Application by Medworth CHP Limited for the Medworth Energy from Waste Combined Heat and Power Facility
The Examining Authority's written questions and requests for information (ExQ2)
Issued on 5 June 2023

ExQ2: 05 June 2023**Responses due by Deadline 5: 16 June 2023**

## Access and Public Rights of Way Plan

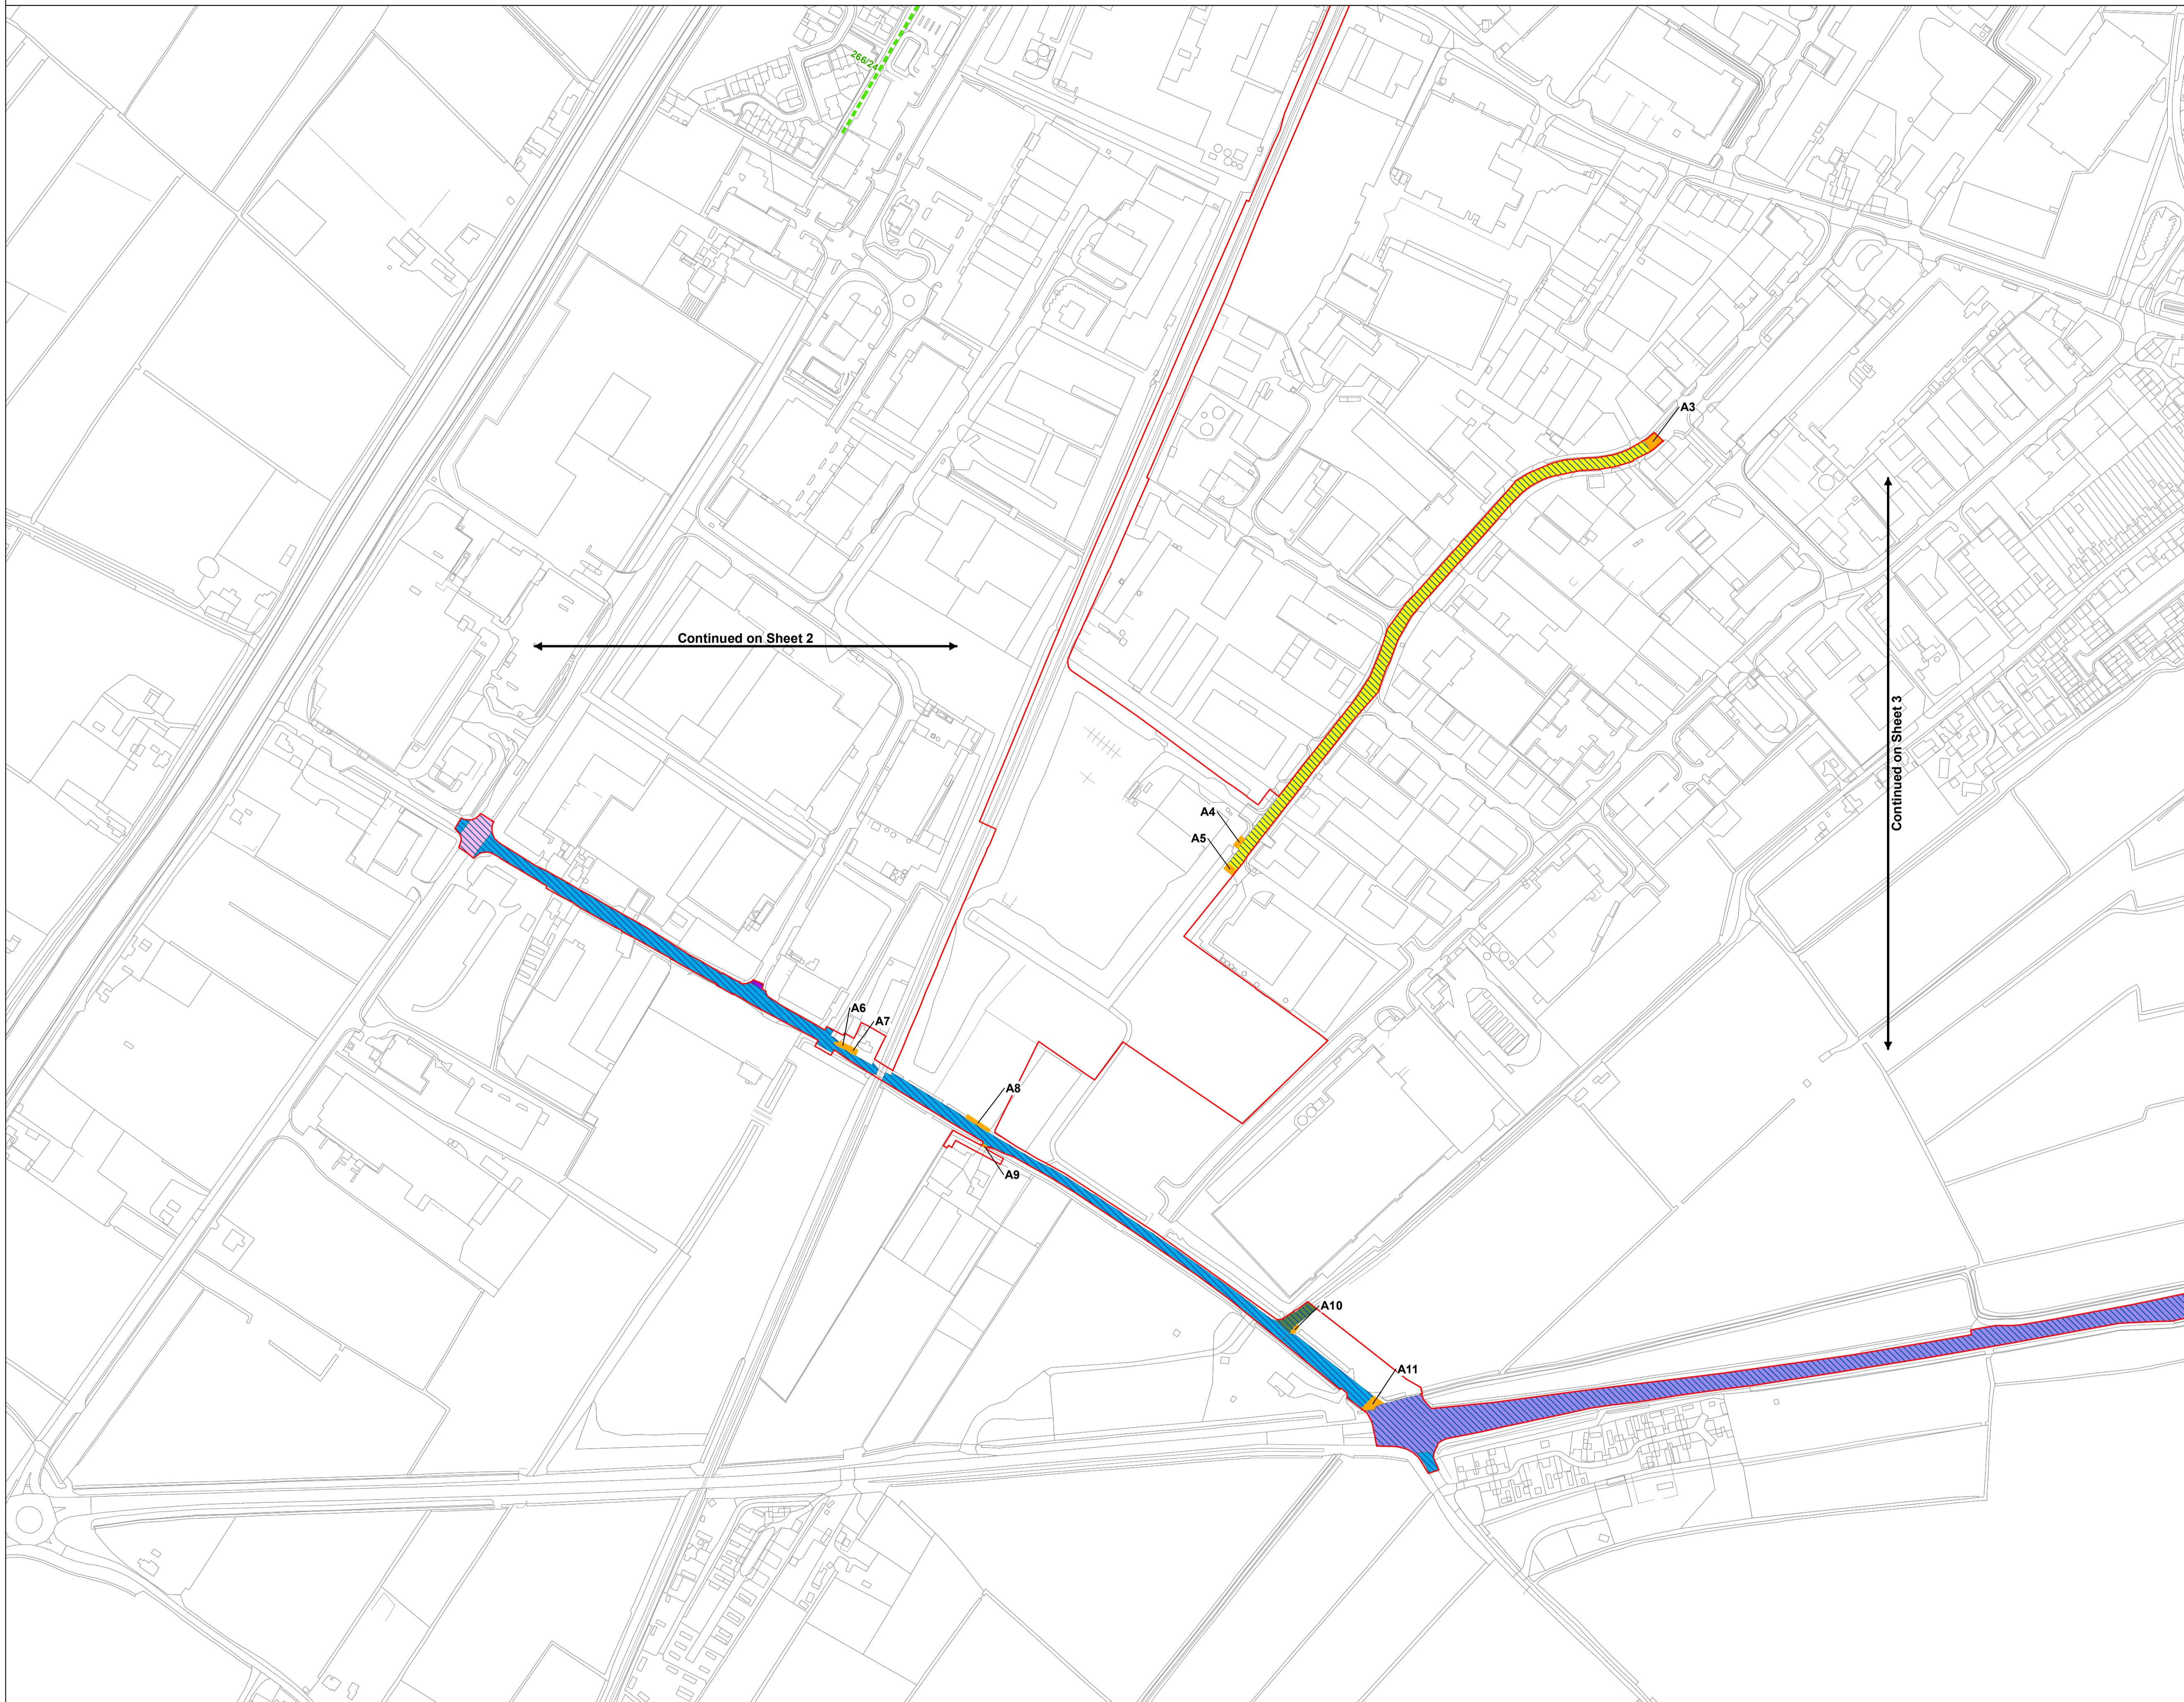
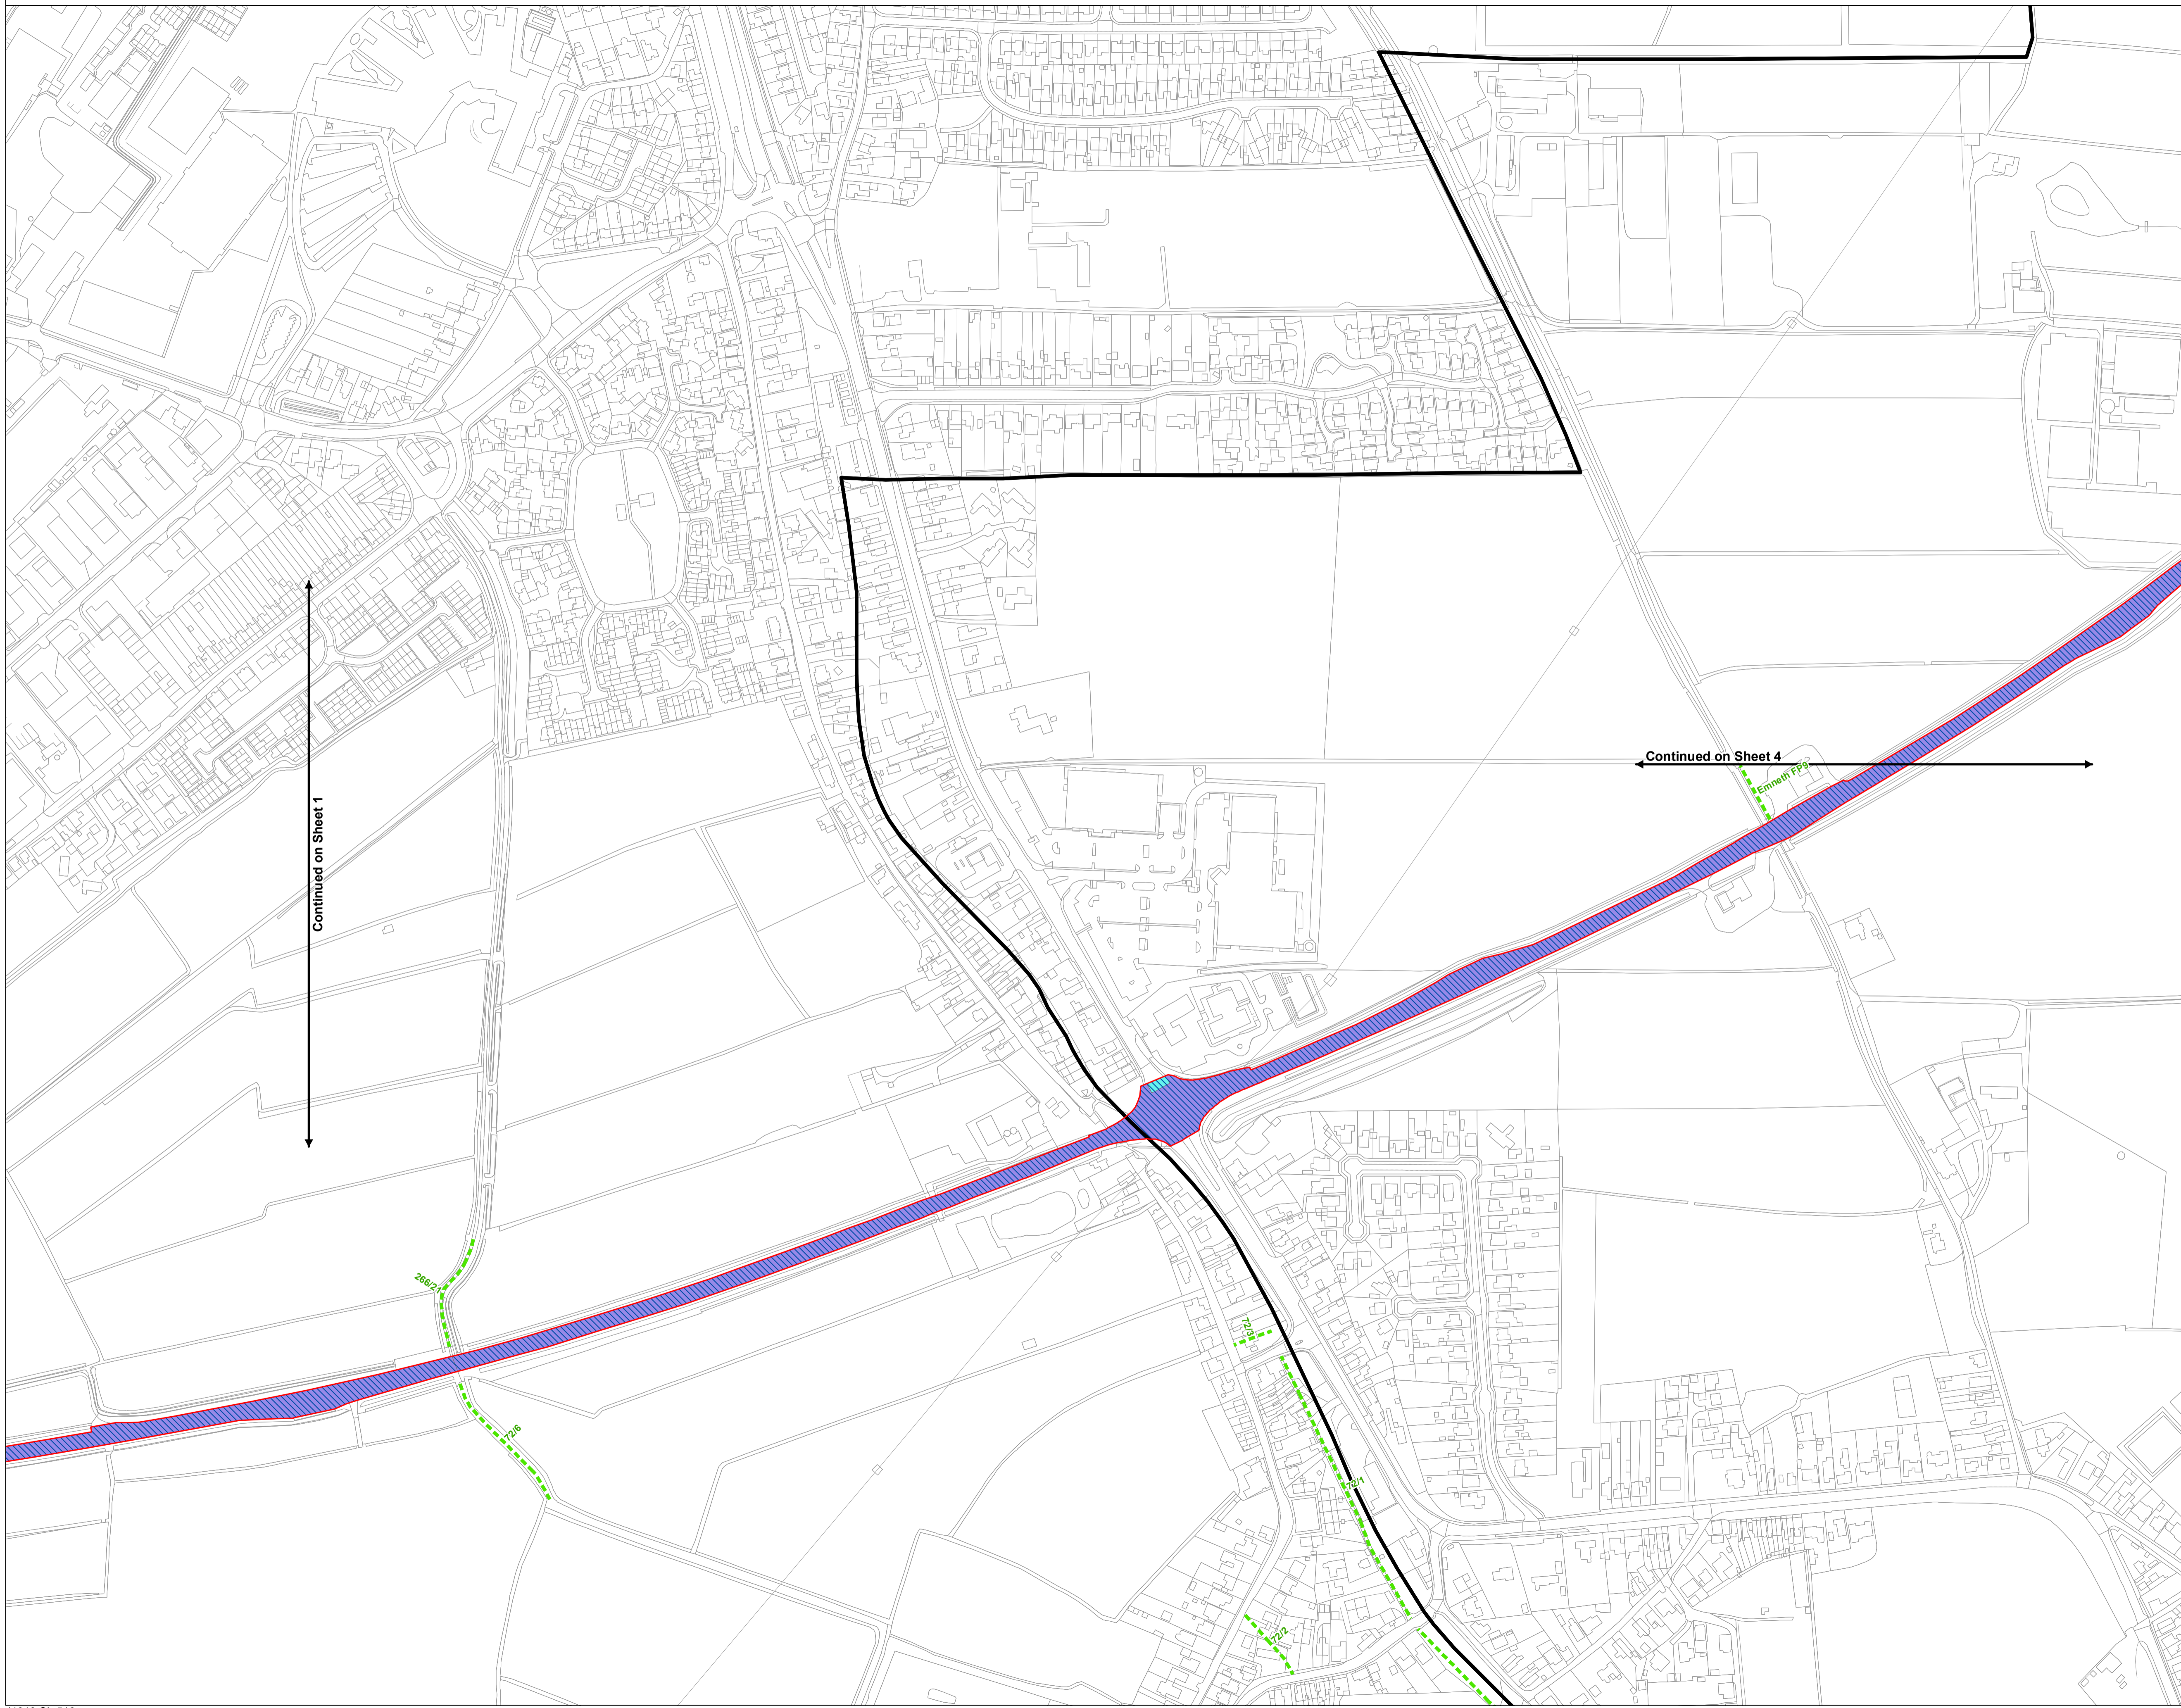
DCO.2.2	Applicant Cambs CC	In response to action ISH2-13 [REP3-038], the Applicant has stated that prior to Deadline 3, it met CCC to discuss highway matters on the 13 April 2023 and is liaising with them regarding predevelopment condition surveys and s278 obligations. Can the Applicant and Cambs CC please update the ExA on any developments following from Deadline 3?
DCO.2.3	Cambs CC	Action IHS2 (sic) [EV-032] asked for the Applicant to review its position in relation to the A47 and review which Table of Schedule 6 of the DCO [REP3-006] it should be included in. In its response to IHS2-15 [REP3-038], the Applicant stated that "The Access and Public Rights of Way Plan (Volume 2.4) (Rev3) [REP1-003] shows the location of the various permanent and temporary accesses required to facilitate the Proposed Development. Access A11 is located at the southern end of New Bridge Lane and abuts the A47. (...) Access A11 is required temporarily for the construction of the Grid and Water connections only. No permanent access is being constructed in this location; all HGV traffic to the facility will use the existing roundabout between the A47 and Cromwell Road, before turning right onto New Bridge Lane and accessing the facility via the permanent access being constructed at the location indicated by A8 on the Access and Public Rights of Way

ExQ1	Question to:	Question:
		Plan. The Applicant has included access A11 within Part 3 of Schedule 6, as the works to restore the temporary access will be maintained by the street authority. Can Cambs CC please confirm that they are happy with the response and the inclusion of access A11 within Part 3 of Schedule 6 of the DCO [REP3-006]?
DCO.2.4	Cambs CC	Action IHS2-15 (sic) [EV-032] asked for the Applicant to refine and clarify Tables in Schedule 6 "Access" with Cambs CC, in relation to consents regarding access, particularly Table 4 and Table 5. In its response to IHS2-15 [REP3-038], the Applicant stated that the amendments had been made to address this issue in the dDCO [REP3-006]. Can Cambs CC please confirm that it is content that the amendments as drafted address their concerns on this point?
DCO.2.5	Applicant UKWIN	The Applicant is asked to check drafting of proposed DCO requirement in relation to moving waste up the hierarchy, as considered for the North Lincolnshire Green Energy proposal and Riverside Energy Park in light of UKWINs submission [REP3-050], [REP4-037] and REP4-038] and how it may impact the wording of Requirement 14 of the proposed dDCO.
